PLANNING DEPARTMENT
CITY OF ALBUQUERQUE

EPC LAND CONTROLS BOARD
May 15, 1975
Z-73-147

Z-73-147 Proposed Development Plan for the Rio Grande Baptist Church on the Southwest Corner of Snow Vista Boulevard & Buenavides Road SW.

DEVELOPMENT PLAN APRIL 15, 1975

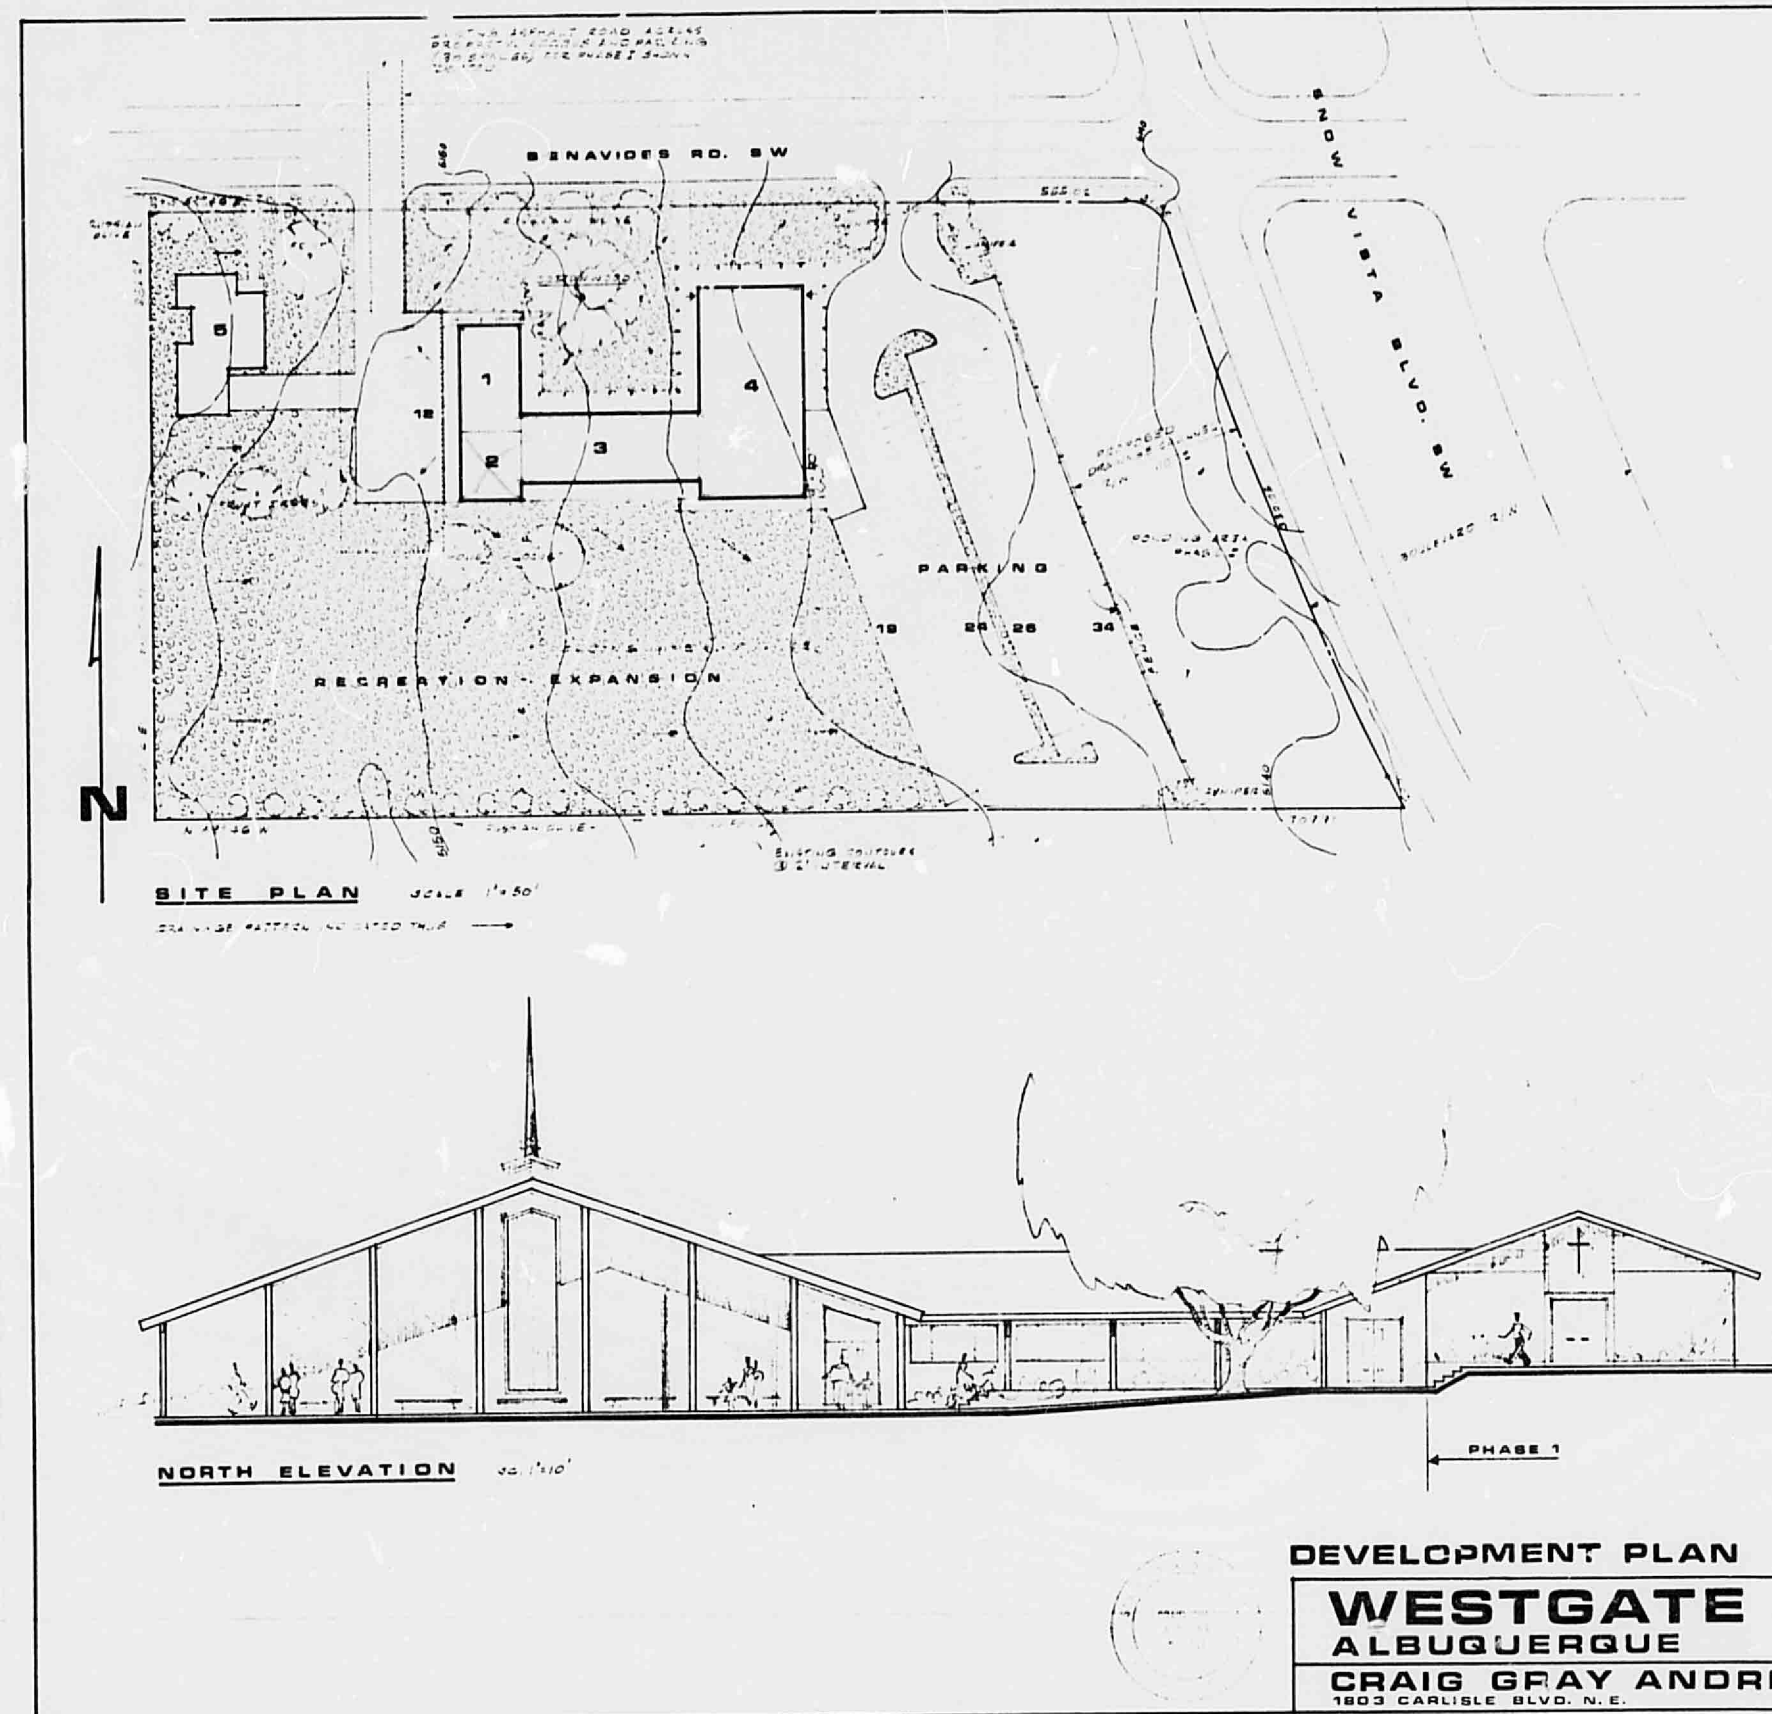
Traffic Engineer: "No objection."
Water Engineer: "No objection. A water line extension per City policy will be required in Buenavides Road for water service."
City Engineer: "A site plan meeting the requirements of AMAFCA Resolution 1971-2 and following guidelines given in verbal conversation with the architect is required."
Liquid Waste Engineer: "No objection."
AMAFCA: "Approved provided drainage is handled as shown."

The site appears to have serious drainage problems, however a ponding area and drainage channel is proposed on the east side of the property where it abuts Snow Vista Boulevard SW. The major portion of the development of this site will of necessity occur in the central and western portions. The drainage plan, according to AMAFCA's comments, conforms with AMAFCA Resolution 1972-2. No further utility service problems exist with the exception of the requirement of a water line extension on Buenavides Road for water service.

The parking requirement is satisfied with the provision of 115 spaces for the completed development. Landscaping appears to be adequate with Russian olive trees serving as a border on the south side of the site along with wood fencing where shown.

Findings: 1. The zoning for the subject site was granted in 1973.
2. The site plan, including the landscaping plan, circulation layout, and parking arrangement, is satisfactory.
3. AMAFCA and the City Engineer must approve the drainage plan prior to final development plan sign-off.

RECOMMENDATION: APPROVAL OF THE DEVELOPMENT PLAN FOR Z-73-147 IS RECOMMENDED SUBJECT TO FINDING NO. 3.
